**KIRKLEES METROPOLITAN COUNCIL
INVESTMENT & REGENERATION SERVICE**

DELEGATED DECISION TO DETERMINE PLANNING APPLICATIONS

Reference No:	2020/62/90667/E
Site Address:	Farmers Boy Inn, 44, Marsh Lane, Shepley, Huddersfield, HD8 8AP
Description:	Formation of new entrance canopy, remodelling of outdoor terraces including introduction of planters, seating, post and rope fencing and lighting, replacement of kitchen extract cowl and part painting of gable (within a Conservation Area)
Recommending Officer:	Ian Lunn

DECISION – Conditional Full Permission

client					
STAR PUBS AND BARS					
address					
THE FARMERS BOY 44 Marsh Ln Shepley Huddersfield HD8 8AP					
drawing title					
PROPOSED GROUND FLOOR PLAN					
drawing no	rev	date	drawn by	checked	scale @ A1
7724-02	a	21.05.18	LB		1:50

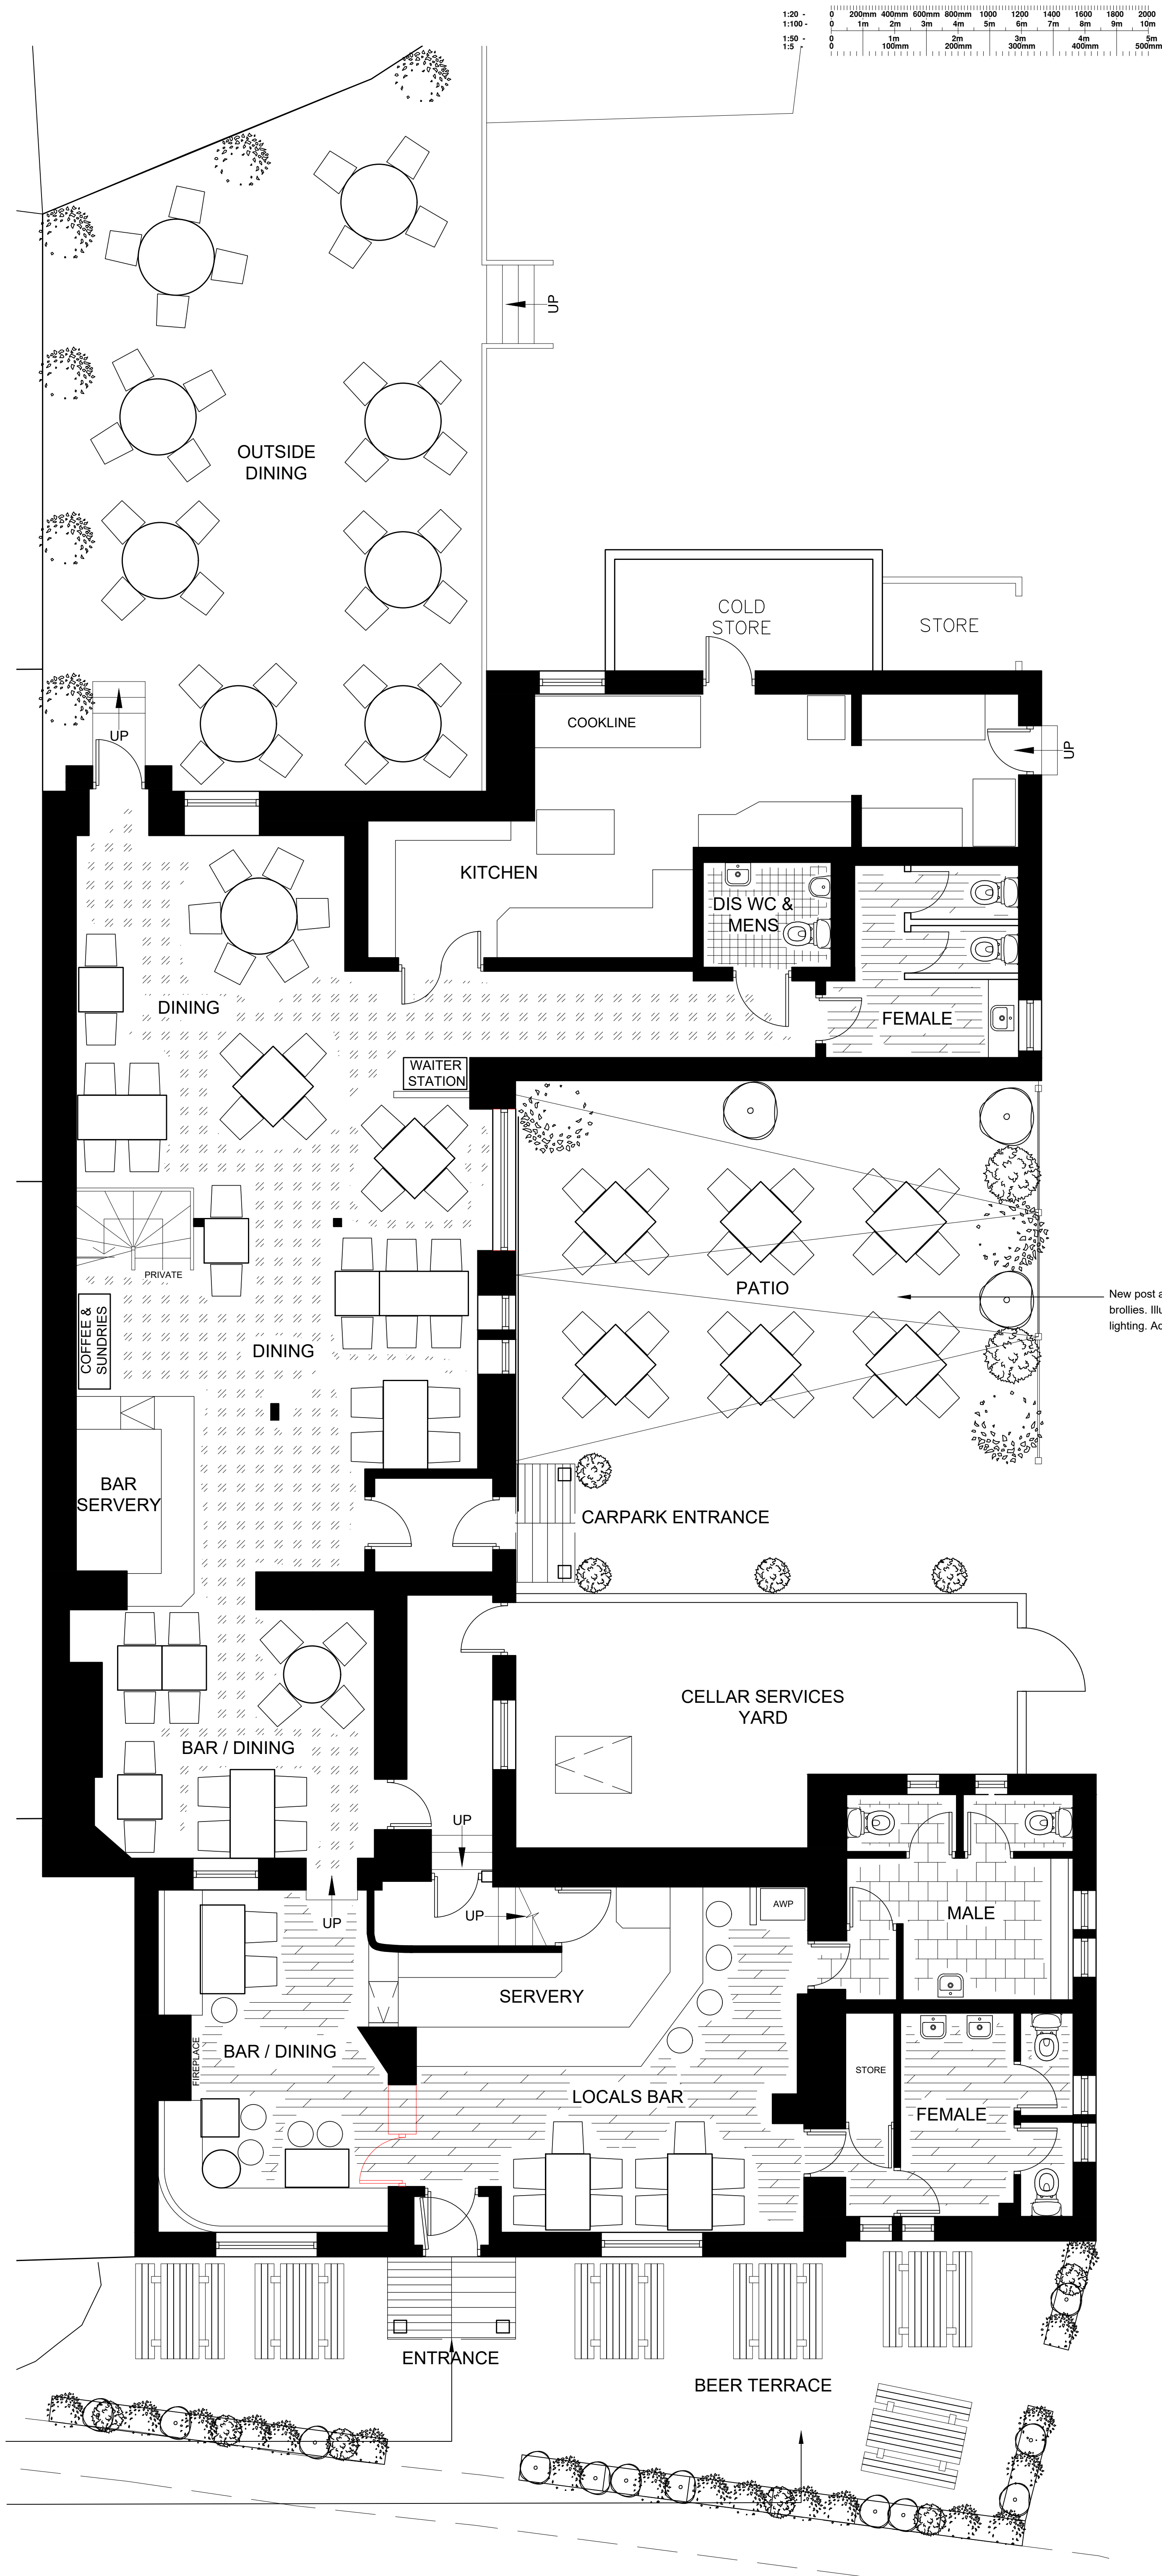
The remodelled seating areas are also considered to be acceptable with the new seats and planters constructed of timber.

It is not envisaged that the proposals will lead to a significant increase in noise over and above any that may have previously been generated by the pub. Whilst they involve the re-modelling of the external seating areas and the introduction of a new cowl:-

- a) the seating areas form part of the existing pub unit and have apparently previously been used for this purpose for some considerable time.

PROPOSED FRONT ELEVATION C-C 1:100@A1

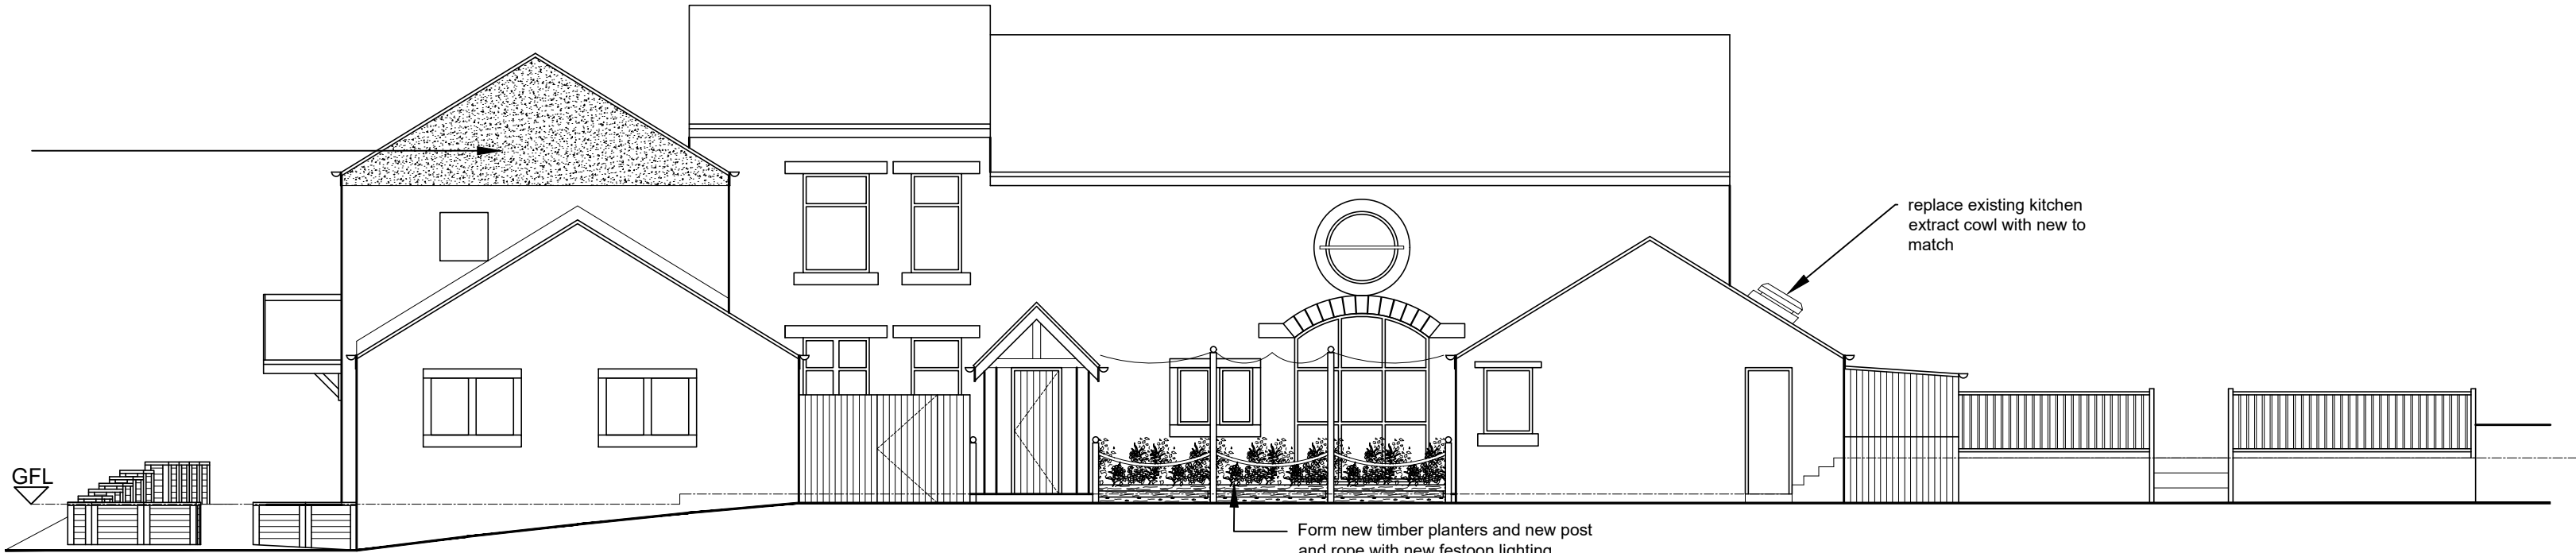
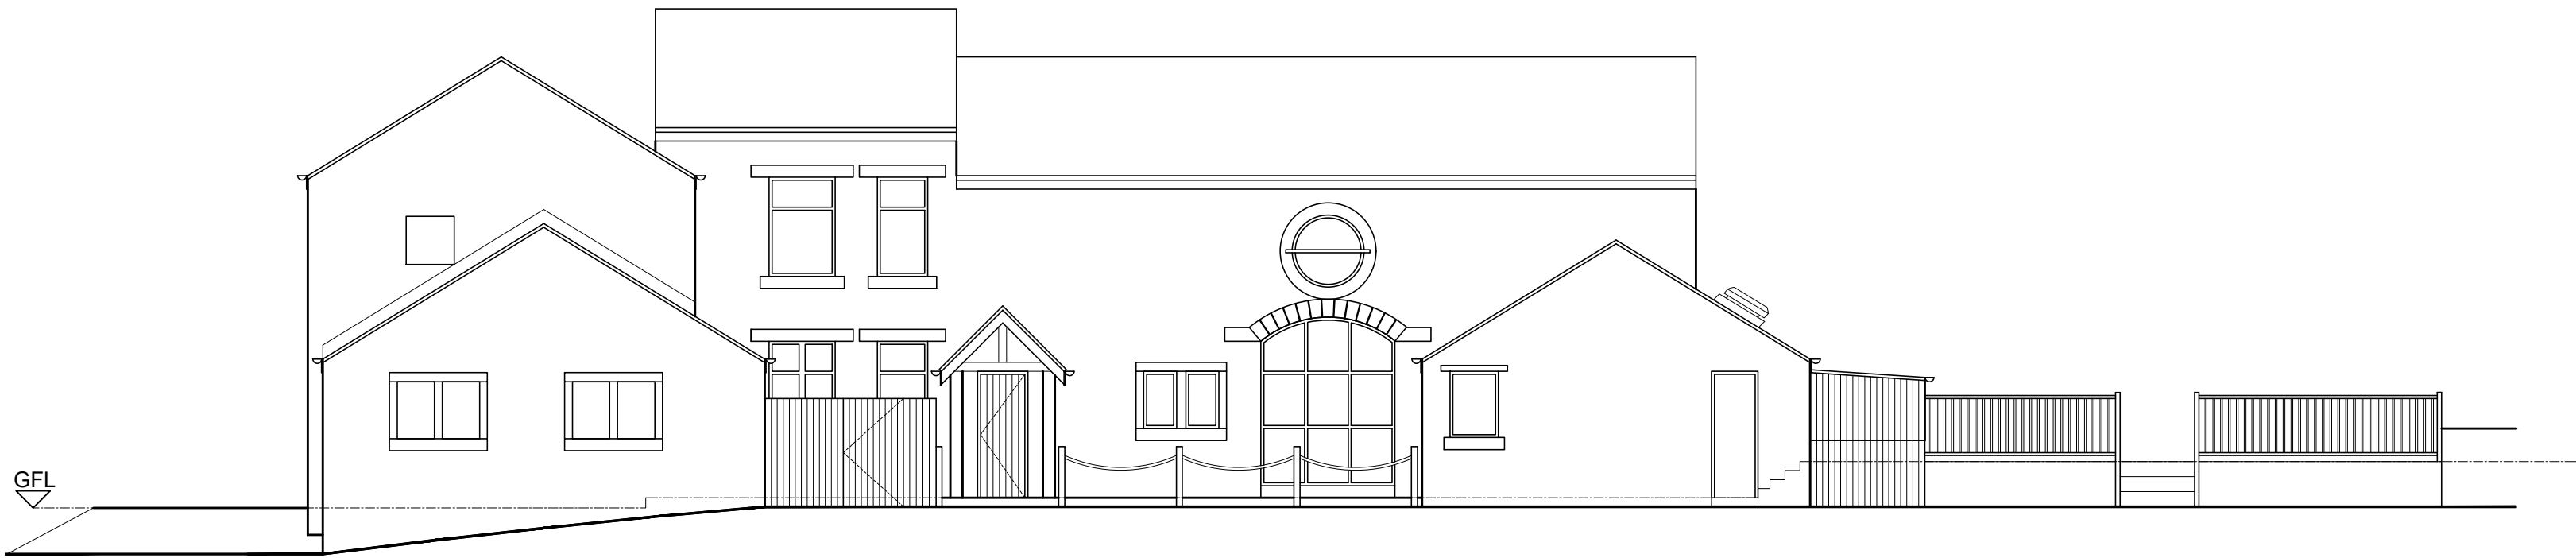
KC Conservation and Design:- Were originally concerned that a porch would appear out of keeping with the character of the terrace of which the pub forms a part. However, following amendments which show the porch altered to a canopy they now raise no objections. Have no objections to the other elements of the scheme.

The new canopy will occupy a prominent position to the front of the building. Nevertheless, following recent amendments it is now considered to be acceptable in design, scale and positional terms despite concerns to the contrary. Whilst it is to be added to the front of the premises it should remain subservient to them as it will be open sided, very modest in size and will be viewed against the significantly larger backdrop of the host building. It will also incorporate a pitched roof that will suitably harmonise with the roof of the host building and it is to be constructed of what are considered to be acceptable materials namely oak for the supporting beams and matching stone slate for the roof.

3. The approved canopy shall be constructed of natural stone slates set on a natural oak frame. The slates shall match in type, colour, texture, and shall be laid in a manner to match, those used in the construction of the roof of the host building.

PROPOSED SIDE ELEVATION B-B 1:100@A1

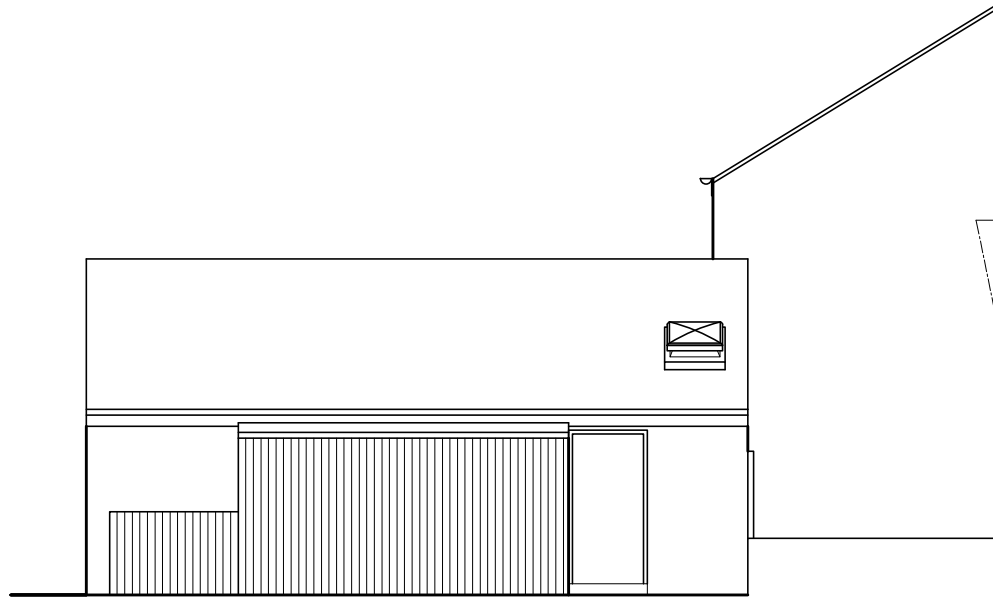
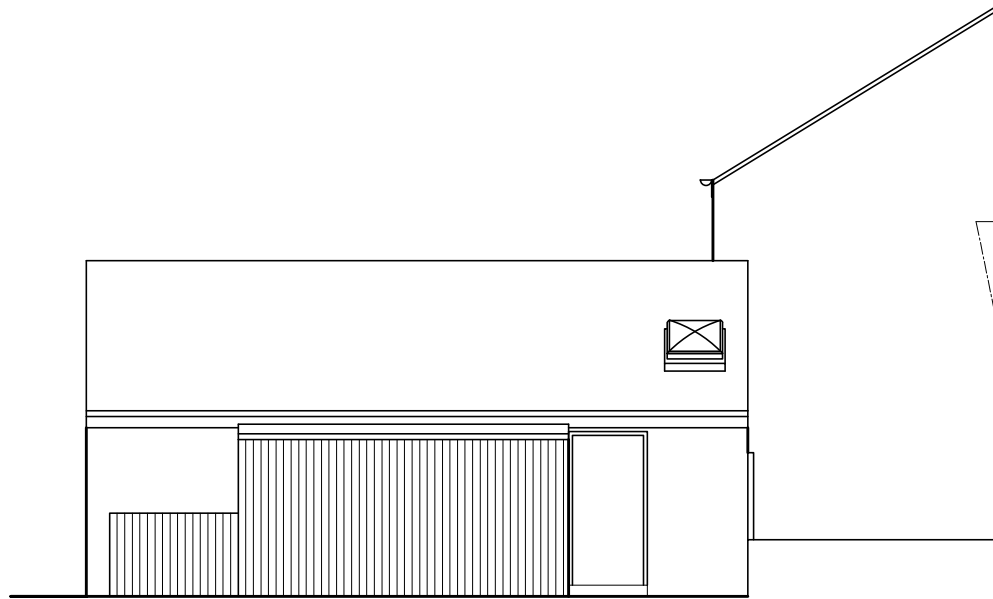
The upper portion of the north eastern facing gable of the building is to be painted 'off white'. This element of the scheme is also considered to be acceptable as it is considered that this colour will provide a suitable contrast to the existing stonework

4. The upper portion of the northeastern facing gable of the building shall be painted 'off white'.
